RE: Residential Garage – *Review of Plans and Recommendations*
MCA #2202

McGee Consulting Associates, Inc. (MCA) was asked to review whether the Residential Garage plans prepared by you meet the requirements of the current North Carolina Building Code (2018 NCBC).

FRONT VIEW  
(ELEVATION)

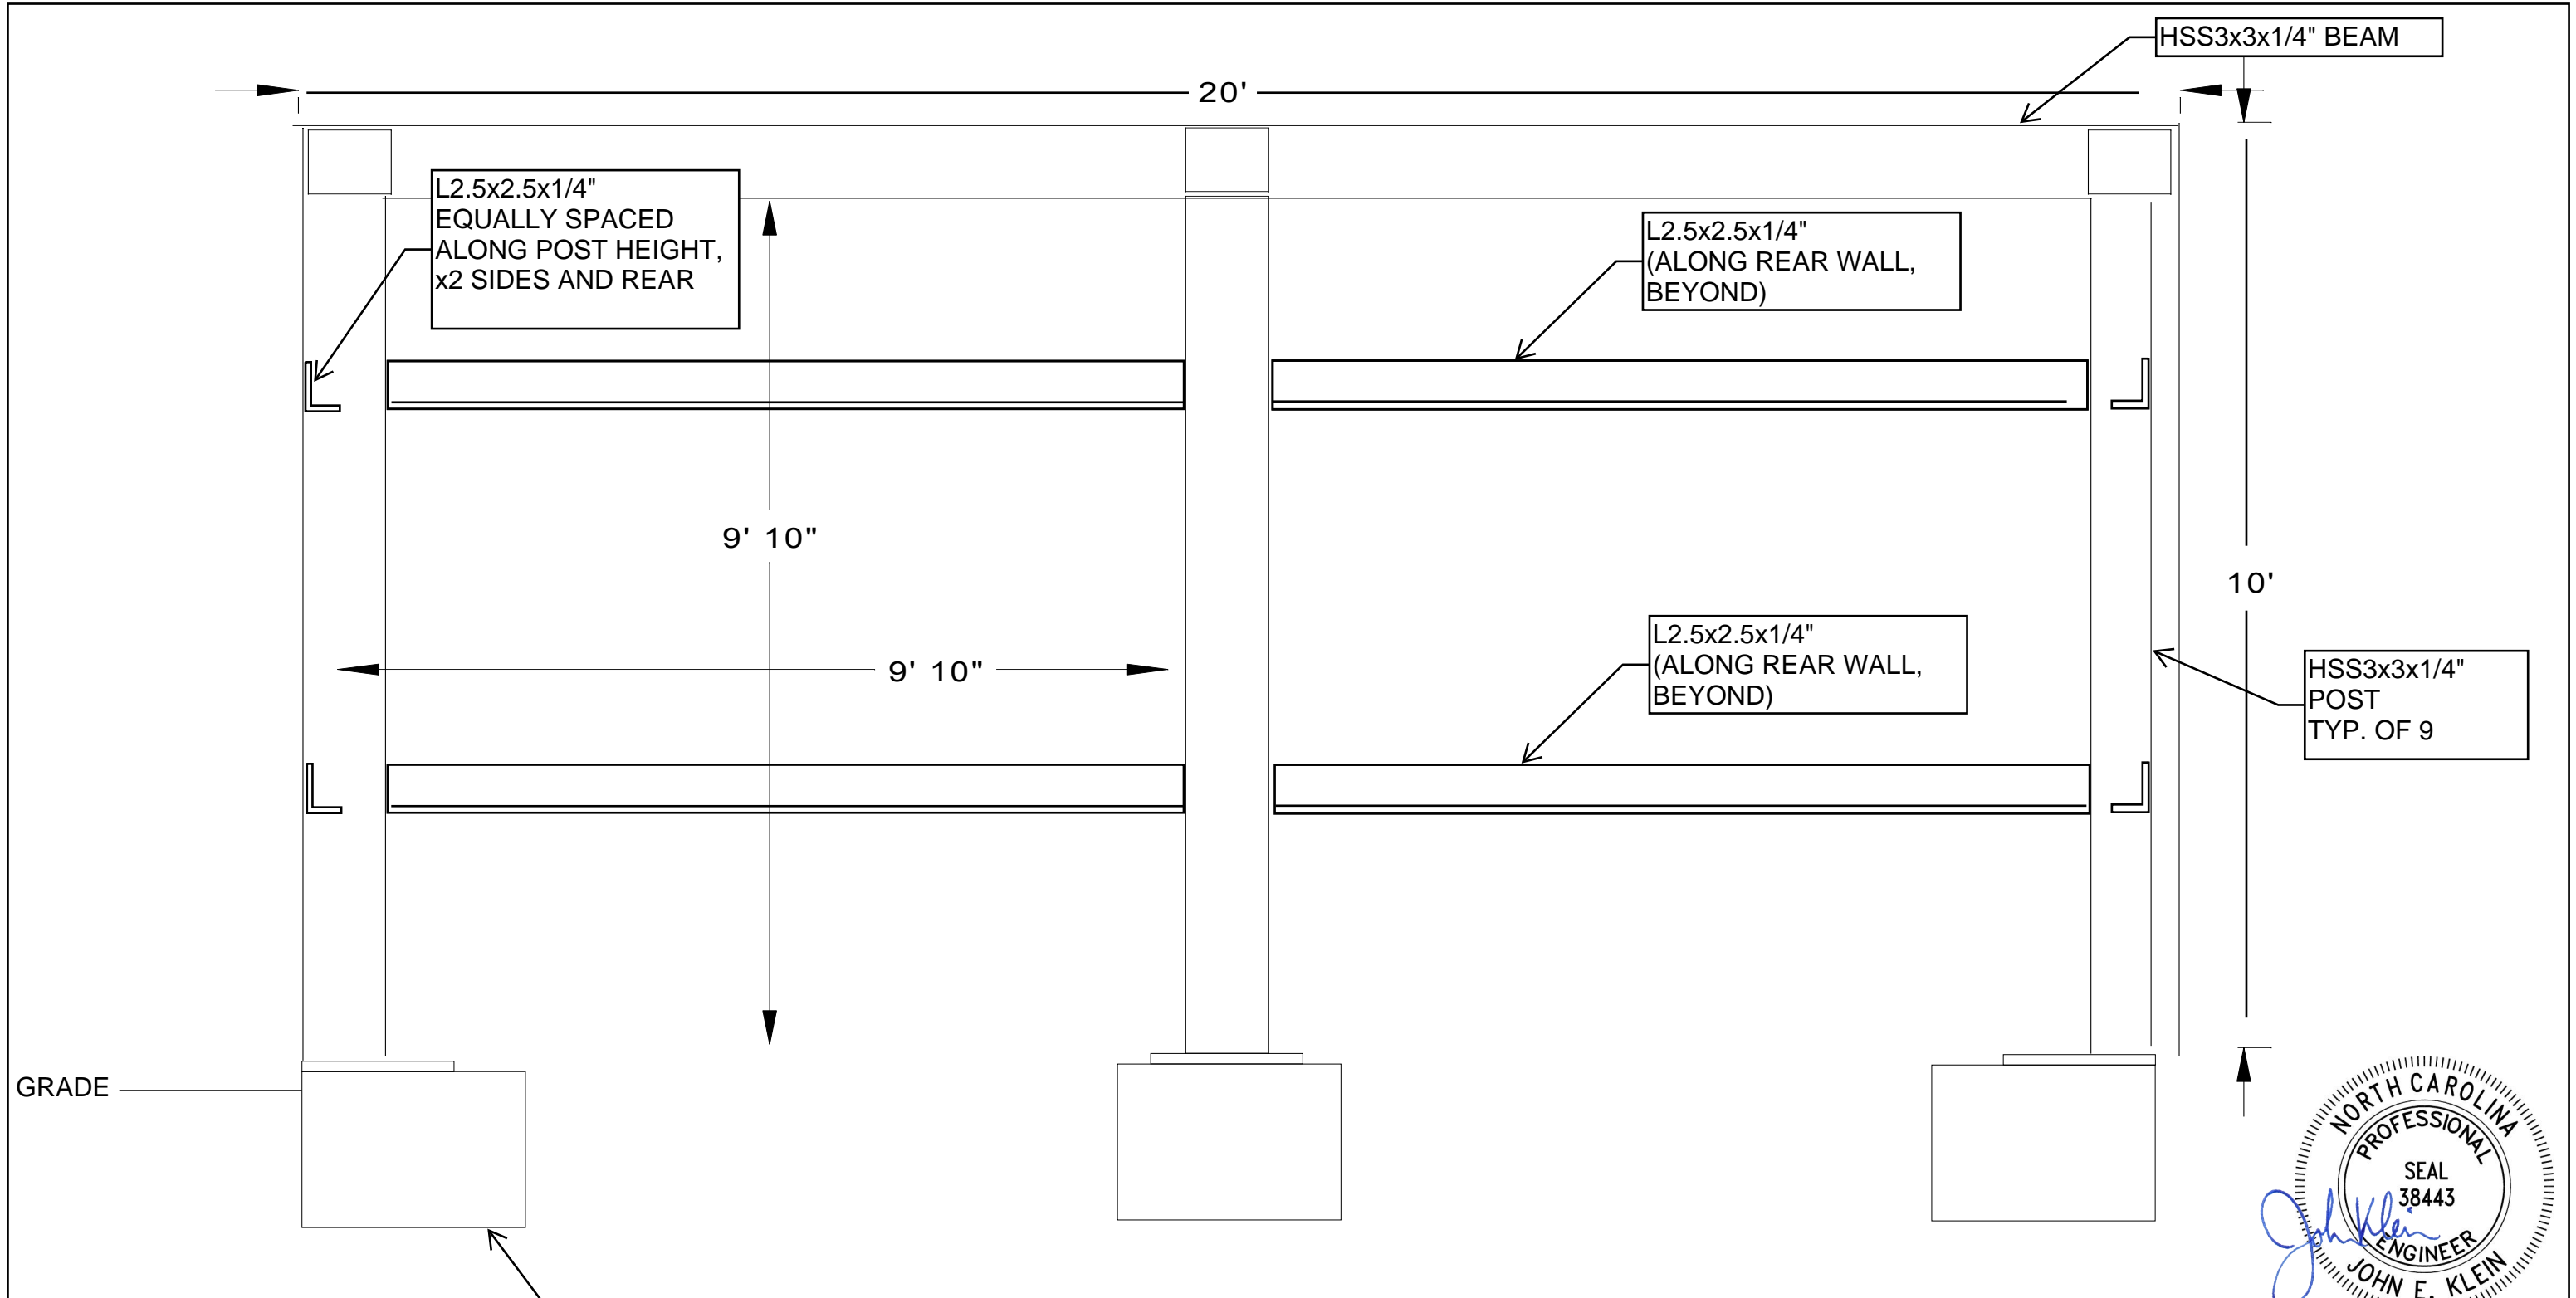
MCA analyzed the proposed beams and determined that the beams have sufficient strength to support the loads, but the beams will over-deflect under the code prescribed loads. MCA has determined the beams must be an HSS4x3x1/4. See the attached sketch for beam size adjustments.

FOUNDATION DETAIL  
(SECTION VIEW)  
(TYP. OF 9)

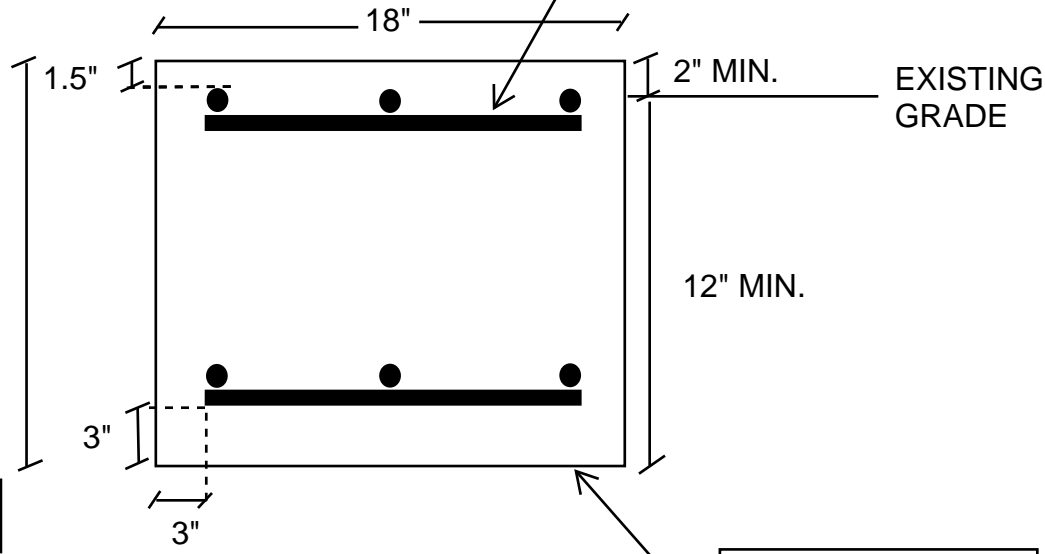
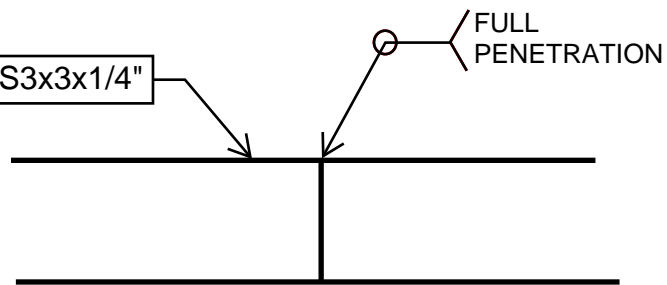
MCA determined that the columns and footings will need to support a load of 3,800 lbs based on the proposed layout. The HSS3x3x1/4 columns will support a load of 20,460 lbs, so the columns will sufficiently support the actual loads. The 18"x18"x14" footings will support a load of 4,500 lbs based on nominal 2,000 psf bearing capacity soil recommended in the 2018 NCBC, so the footings will support the actual loads.
